Engineers Comments Regarding Surface Water Drainage

APPLICATION NO: BN/84/19/HH

Site Address: 7 Foxes Croft Barnham PO22 0JT

Description of Works: Porch to front elevation

C		
B		
A		
Client	Mr & Mrs Hughes	
Address	7 Foxes Croft : Barnham	
Drawing	EXTENSION AND PORCH	No. 5419:1
Scale	1:50 1:100	Drawn B
		Date AUG '09

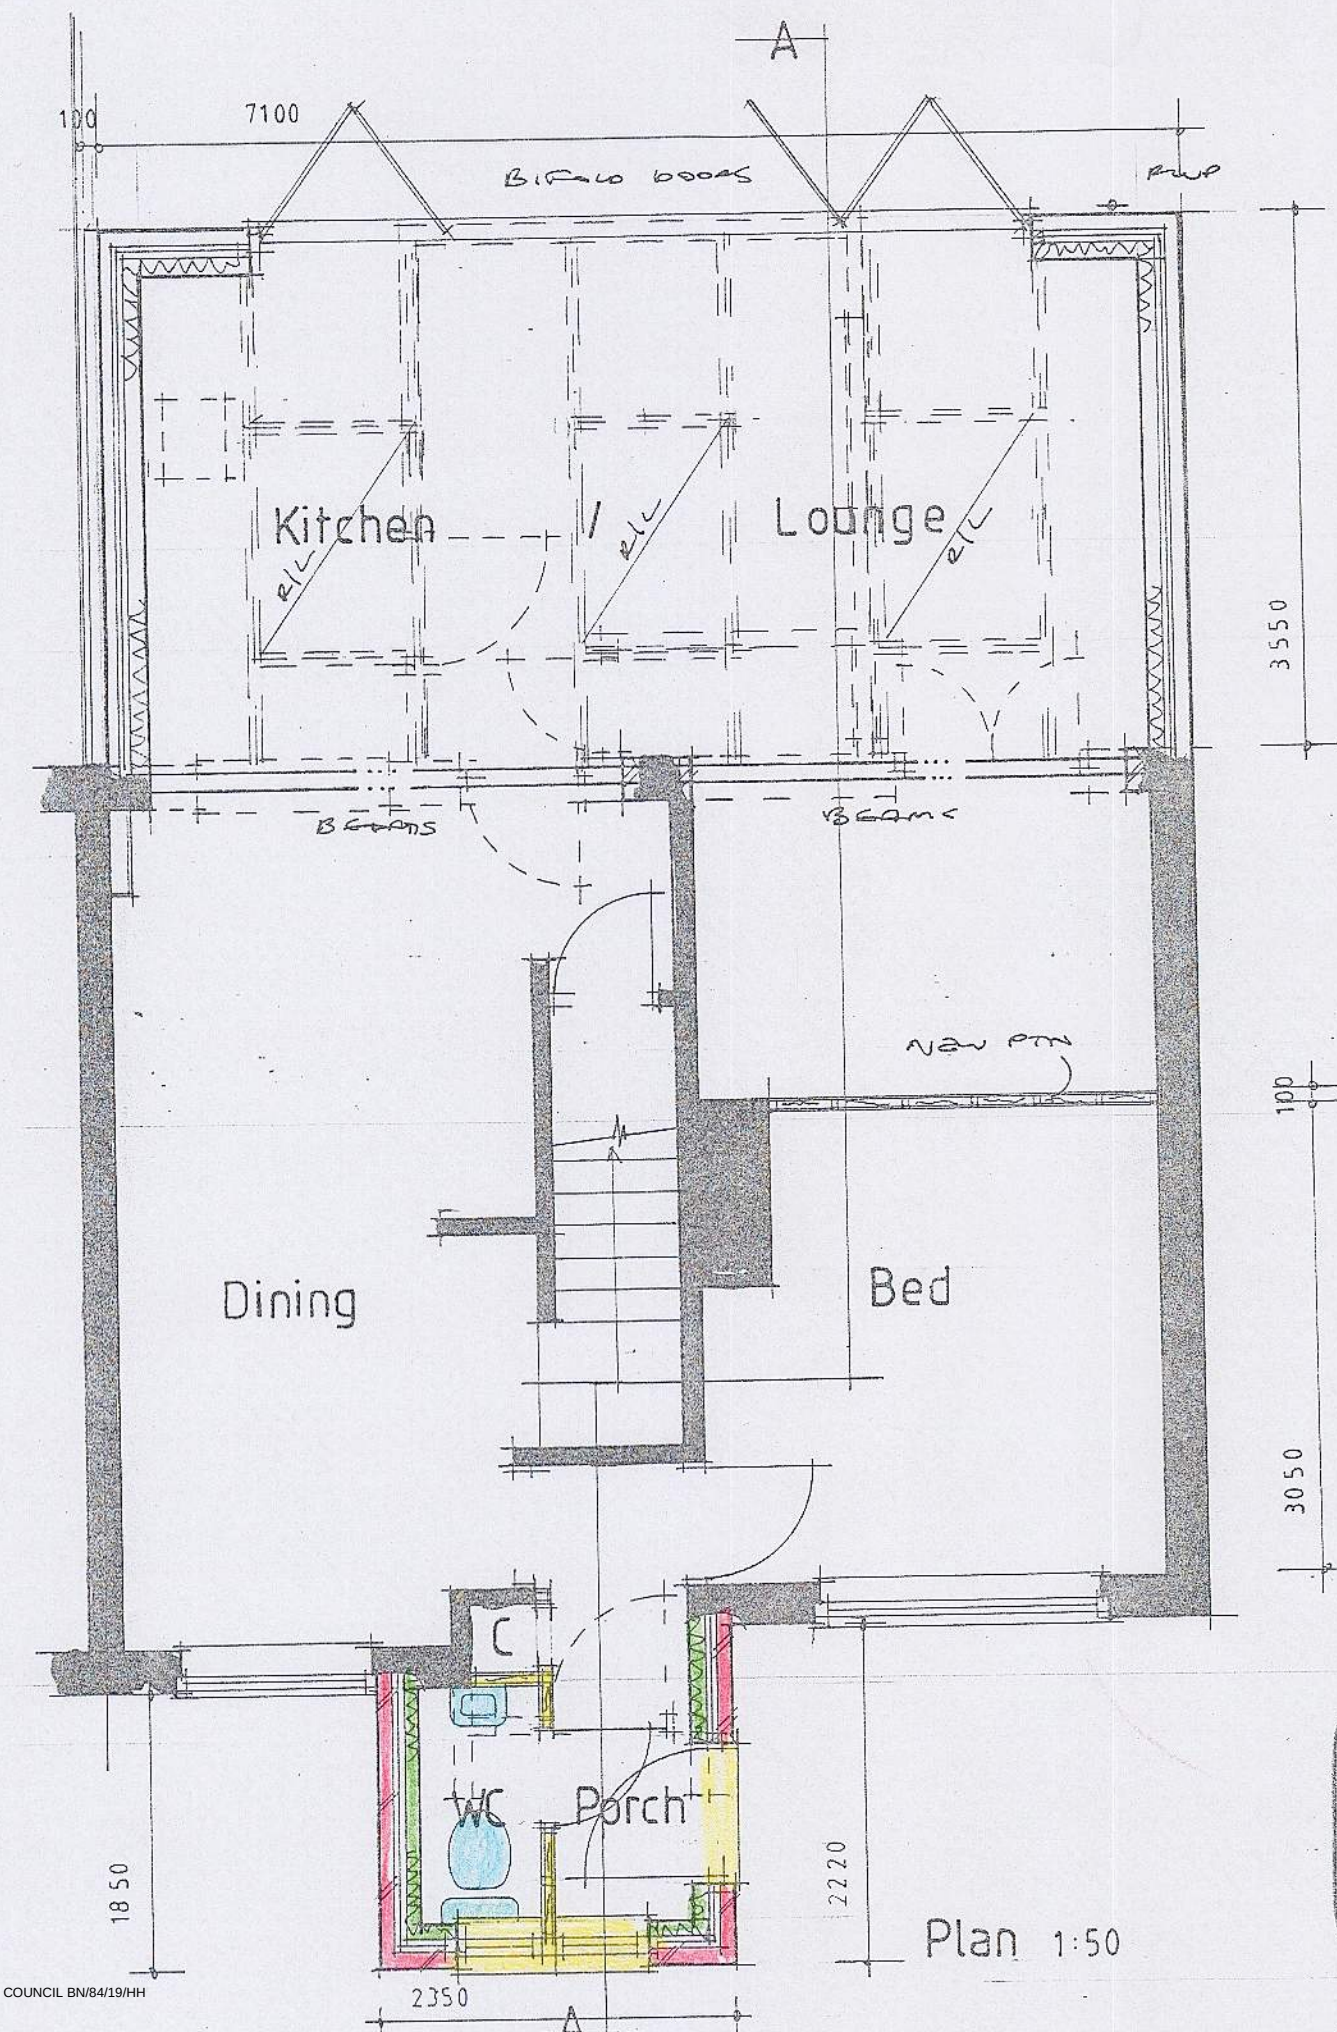
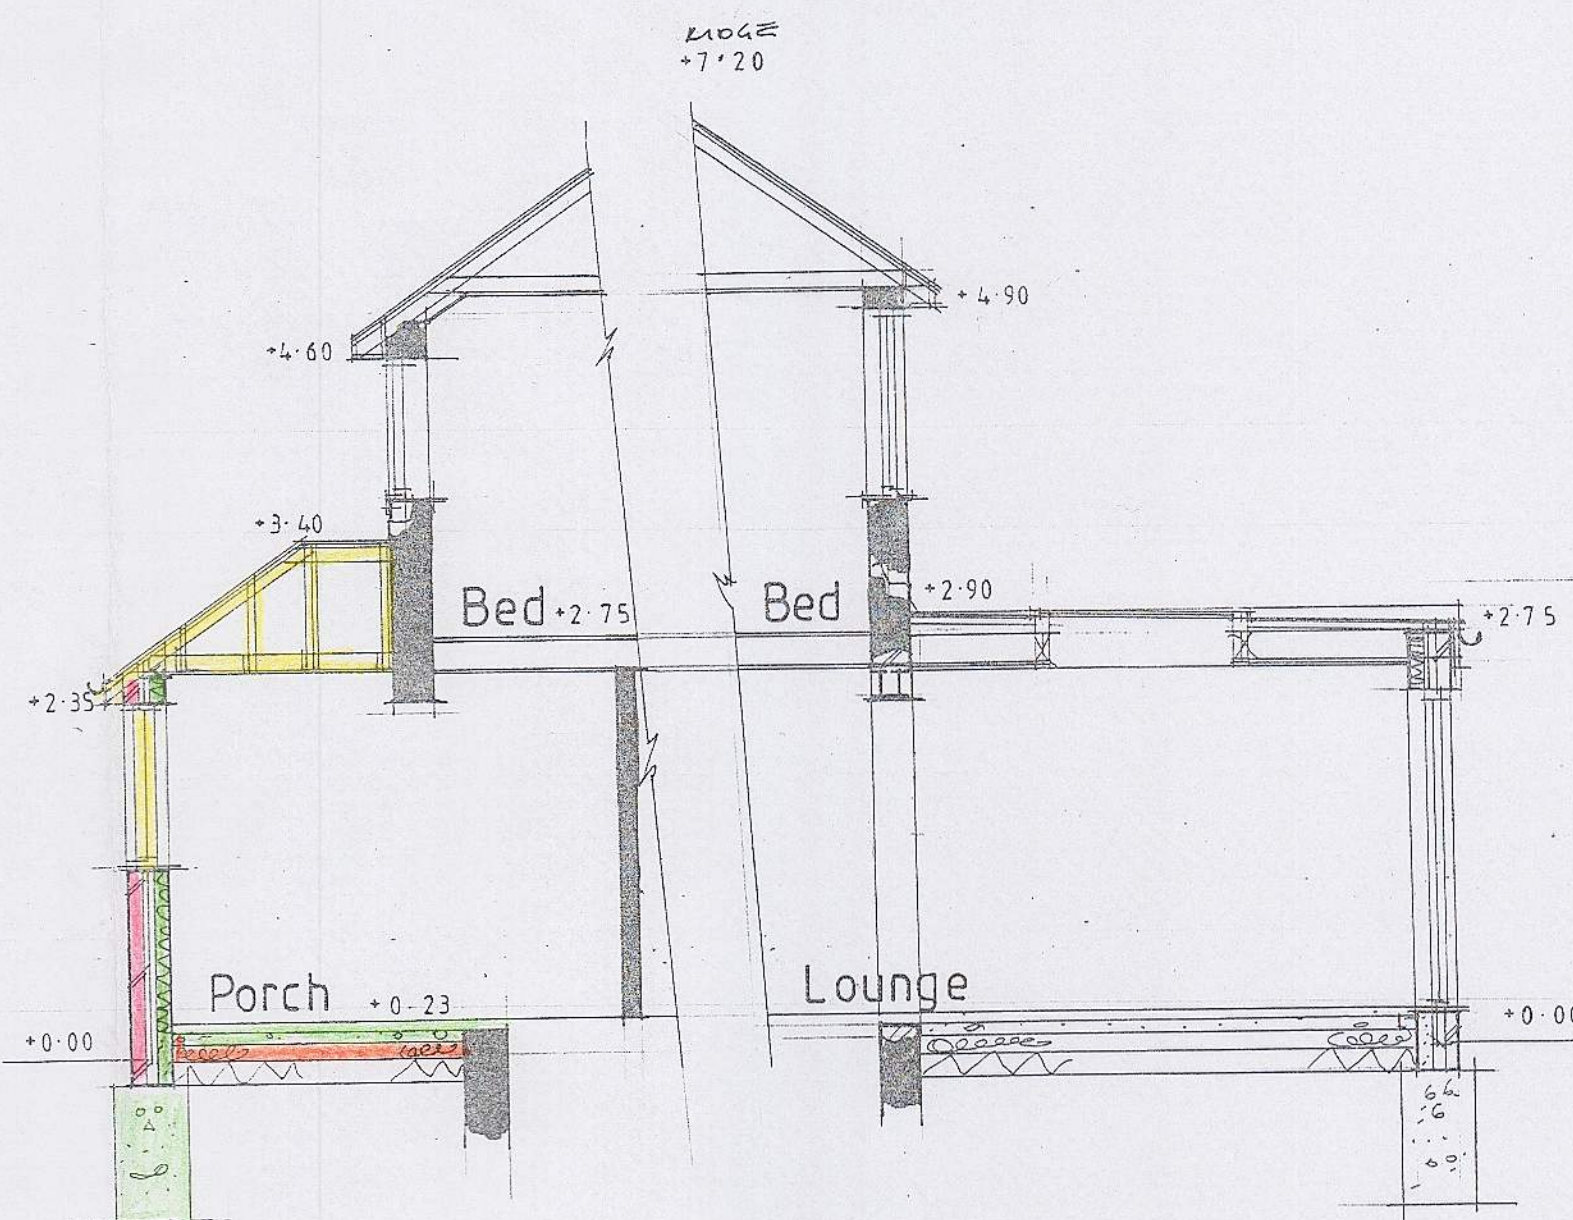
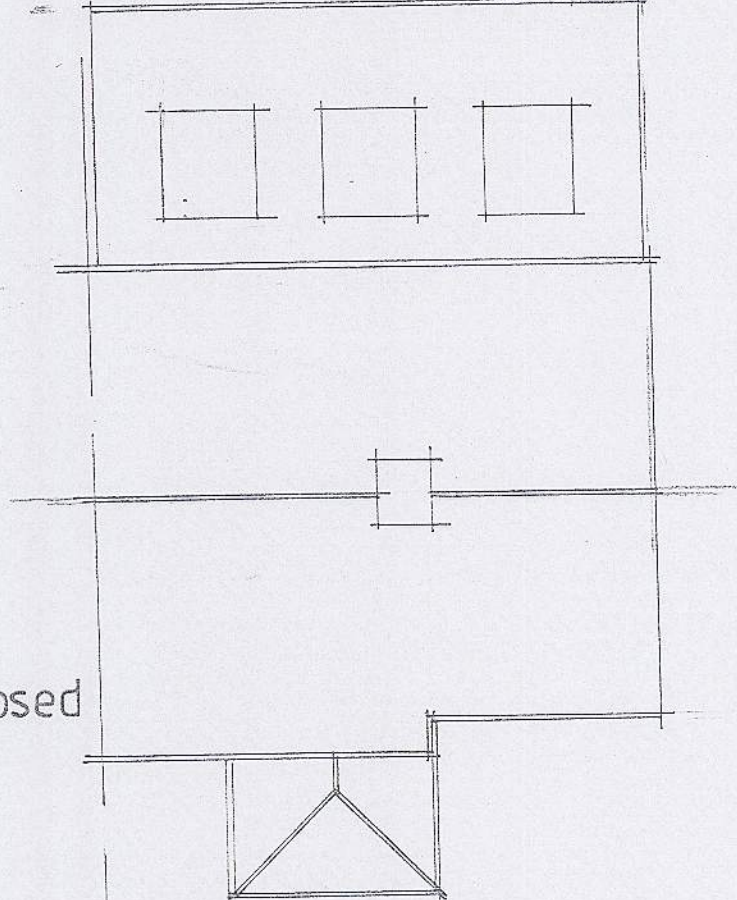
Our records indicate that there may be a sewer under the proposed location for the rear extension. We would advise the applicant to contact Southern Water at the earliest opportunity.
